# DEVELOPMENT HEARING OFFICER

**PR-2021-005684**

SD-2024-00094 – PRELIMINARY/FINAL  
PLAT IDO - 2022

DRB Project Number: 2021-005684  
Mesa del Sol Tracts F-1, F-2 & F-3

SIDEWALK EXHIBIT - TRACT 25

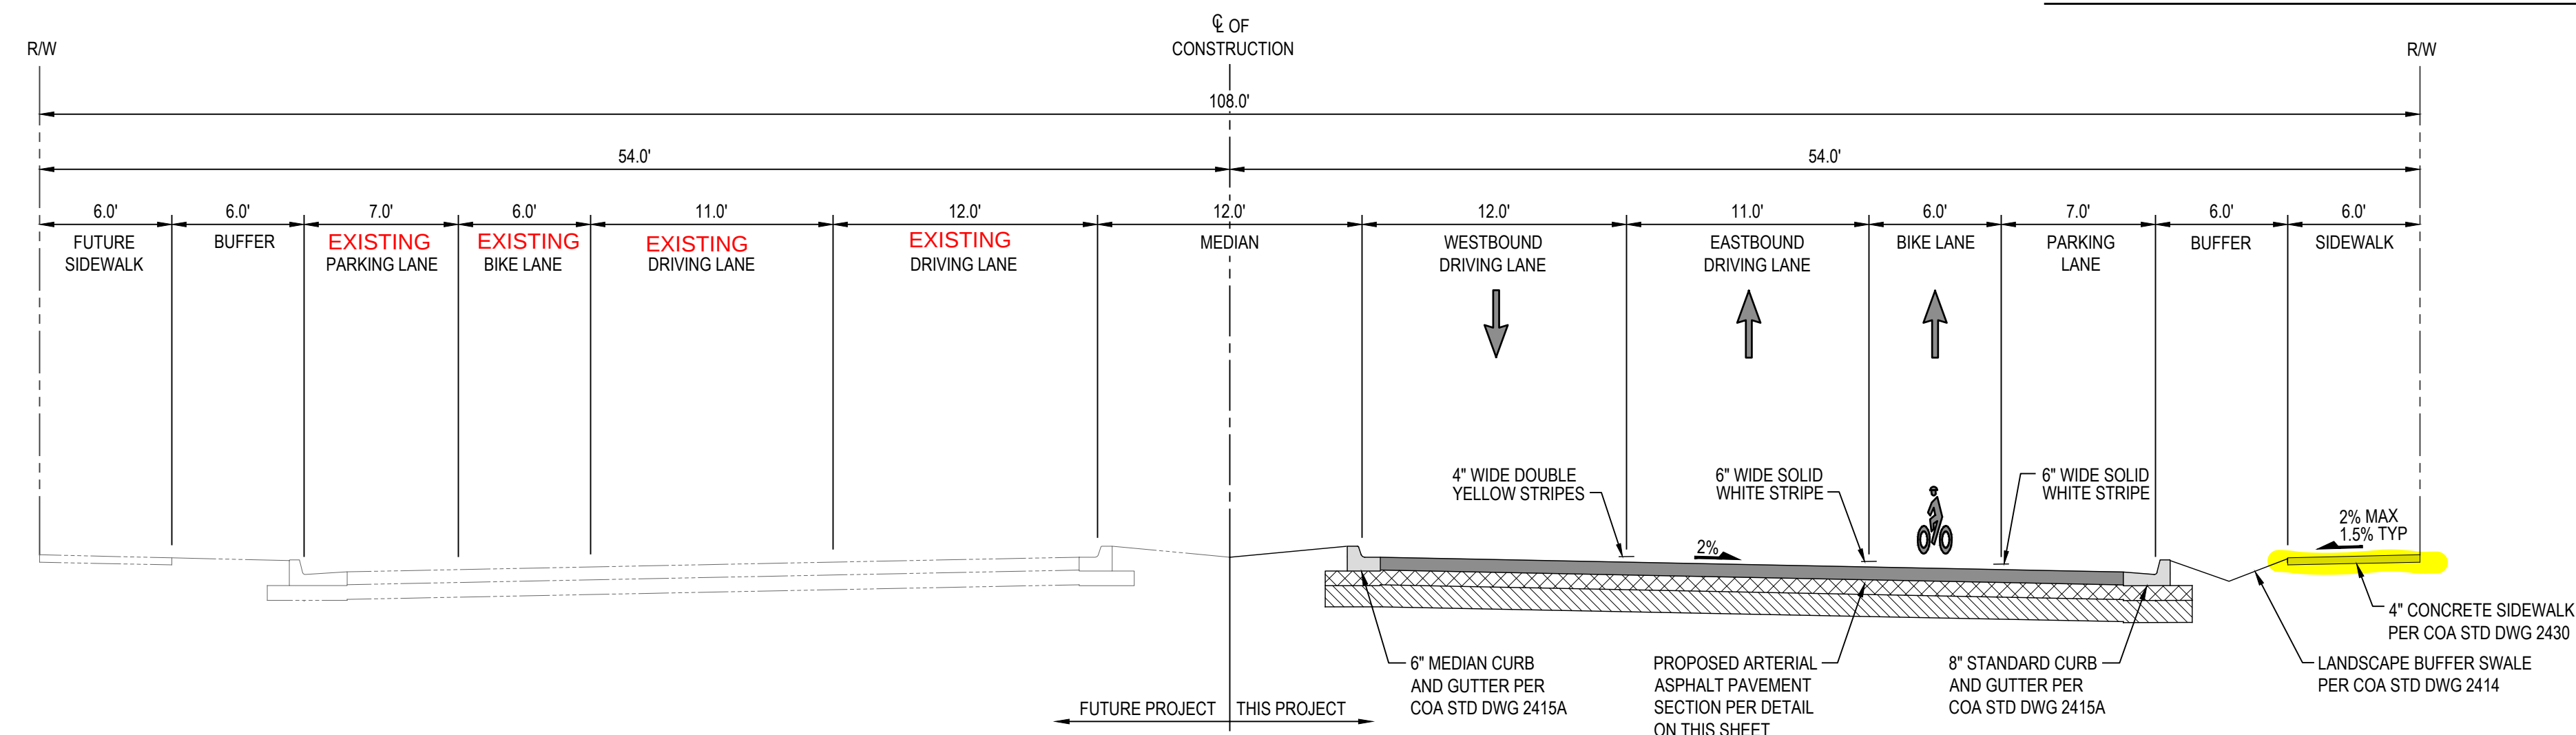
1. Please indicate when deferred sidewalk will be built and under what infrastructure list.  
We need to ensure these improvements will be built and no deferred indefinitely.

- Demonstrate compliance with *Section 7 of the DPM Table 7.2.29, Mesa Del Sol streetscape plan, and the Required Improvements section from 5-4(N) of the IDO.* \*Regarding Sidewalk width requirements and the landscape buffer. Clarify the construction detail and the need for an IL-infrastructure List.  
***\*Verification of standards per Transportation\****
